Reference No:	2025/62/93105/W
Site Address:	3, Woodsome Drive, Fenay Bridge, Huddersfield, HD8 0JR
Description:	Demolition of existing garage and outbuilding, two storey side extension, single storey rear extension, front porch and roof canopy
Recommending Officer:	Joshua Merriman

DECISION – Conditional Full Permission

Officer Report – 2025/93105

Floor Plans - As Proposed

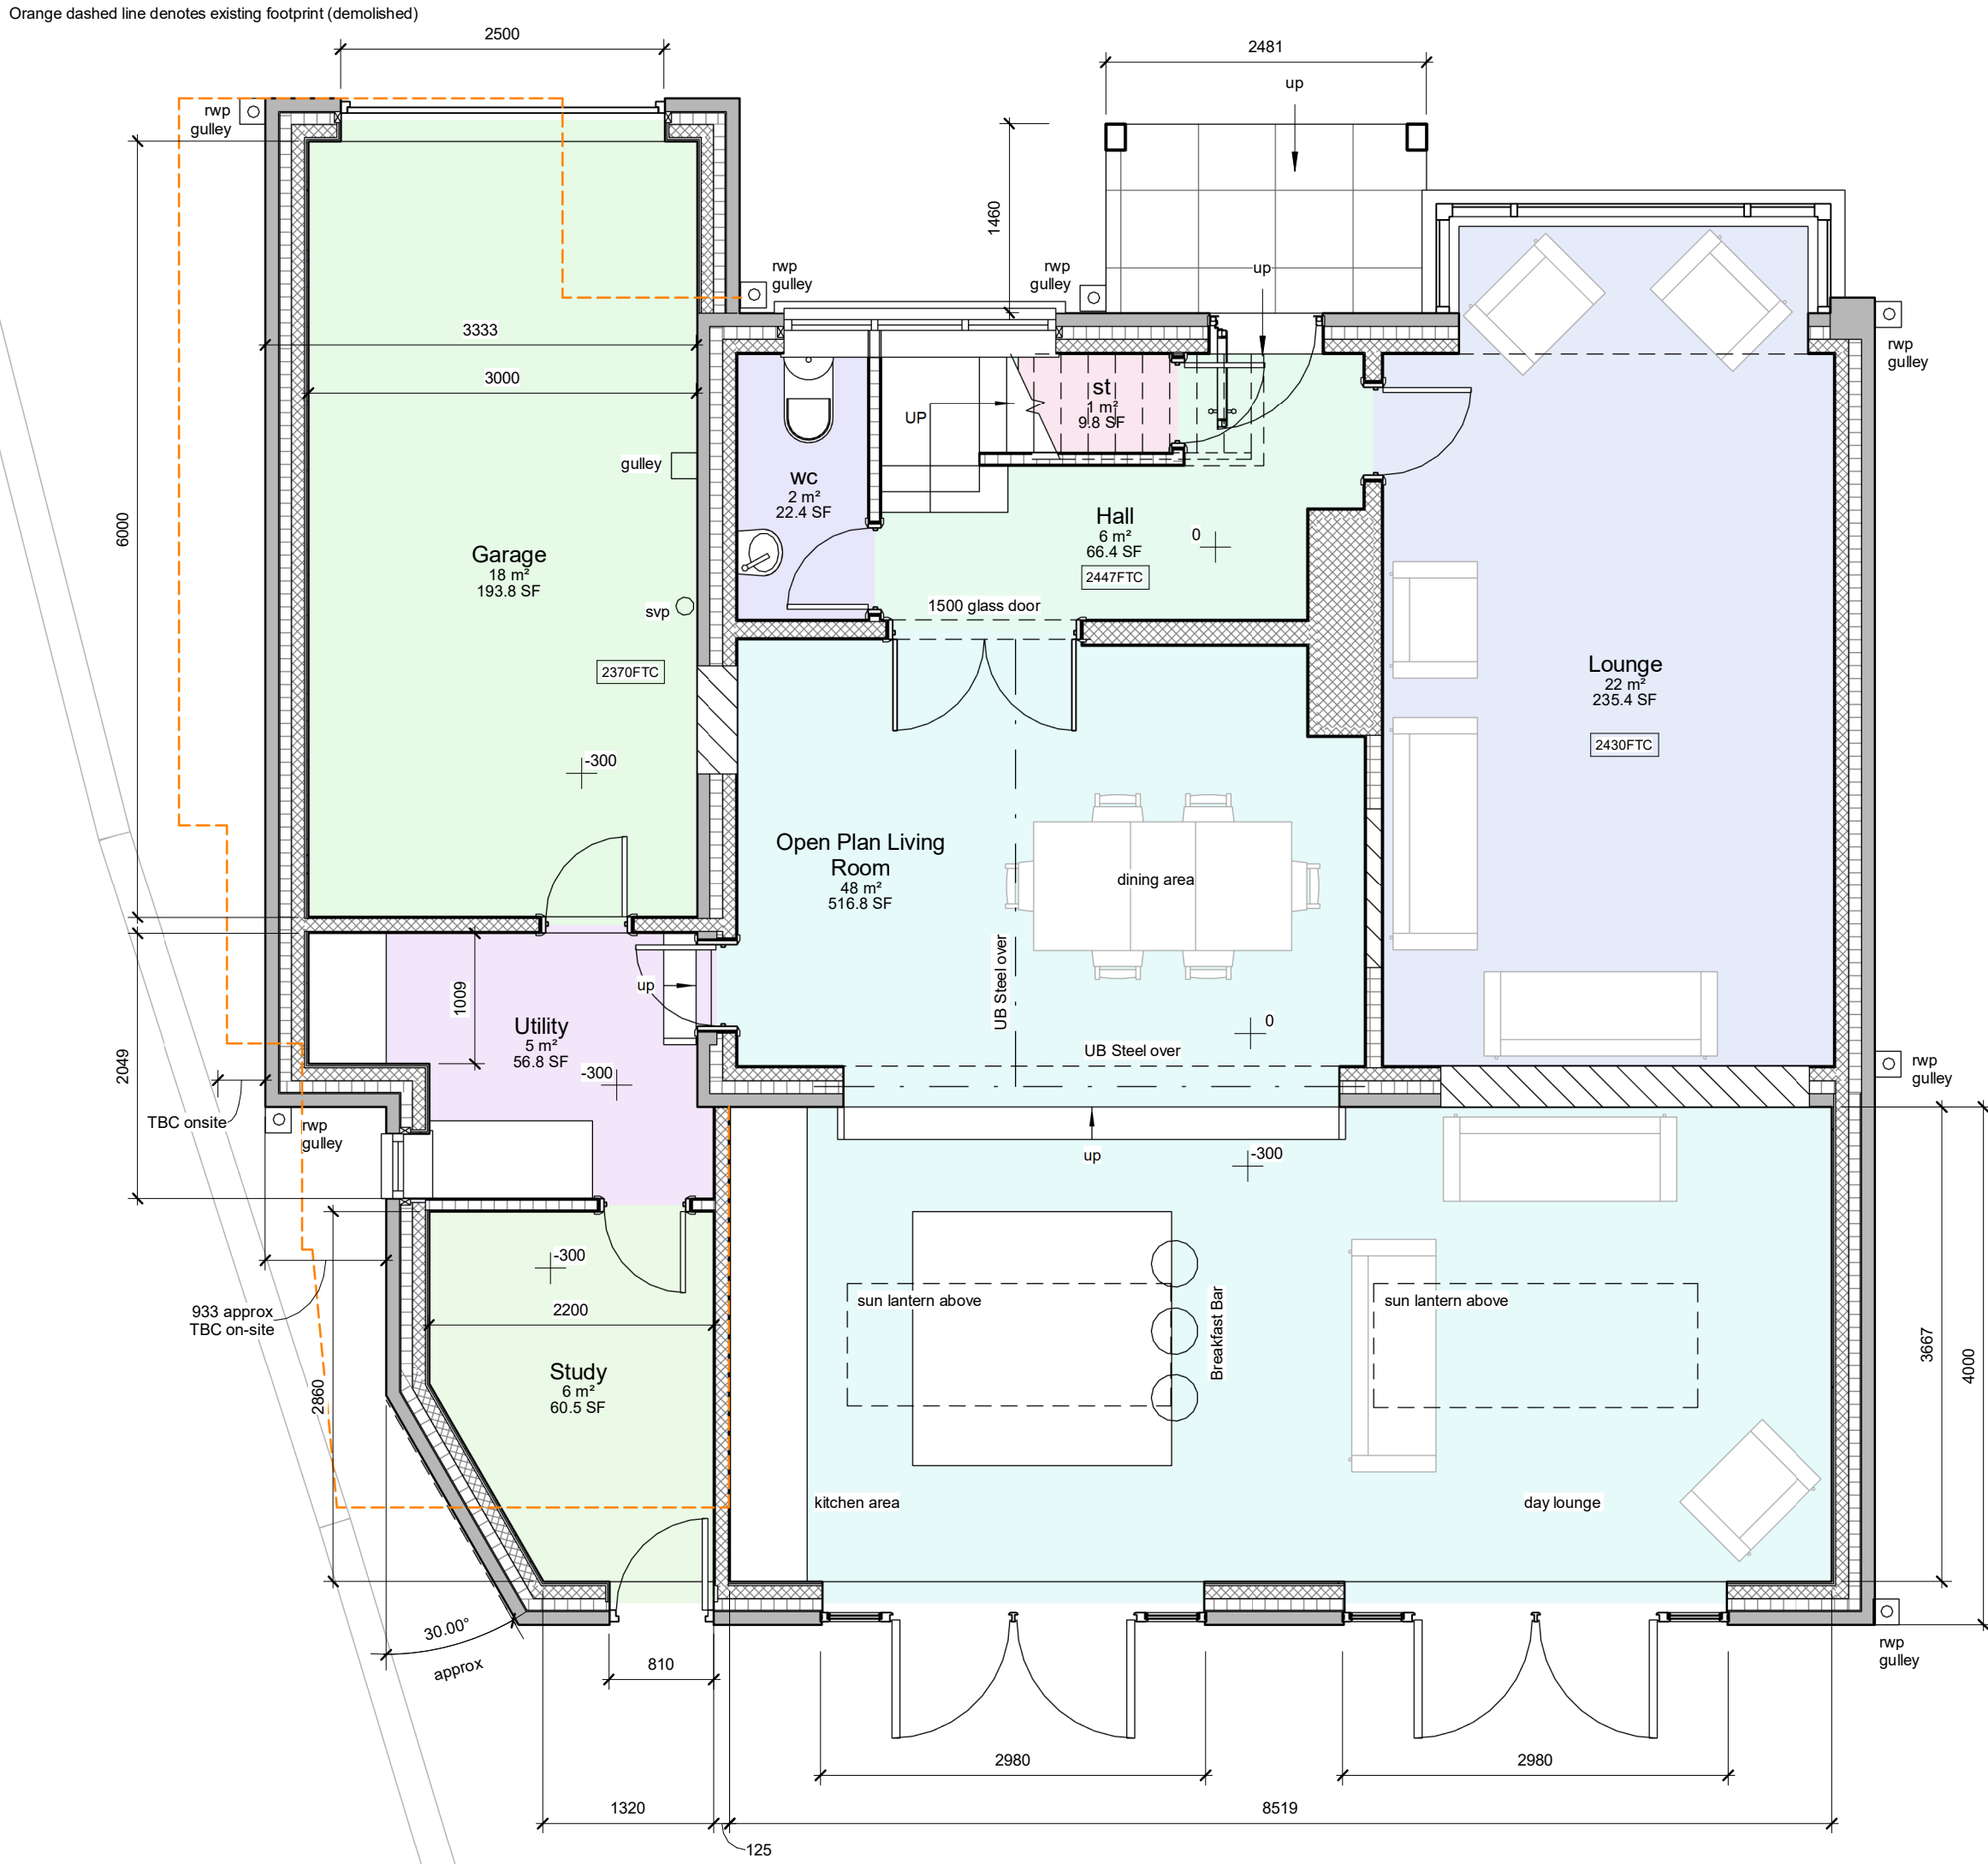
As for the two-storey side extension, it is located far enough away from neighboring properties, retaining a 1m gap to the side boundary, to ensure reasonable levels of natural light to habitable rooms in neighbouring properties, and the absence of side windows and an obscured front window ensures no overlooking or privacy impacts.
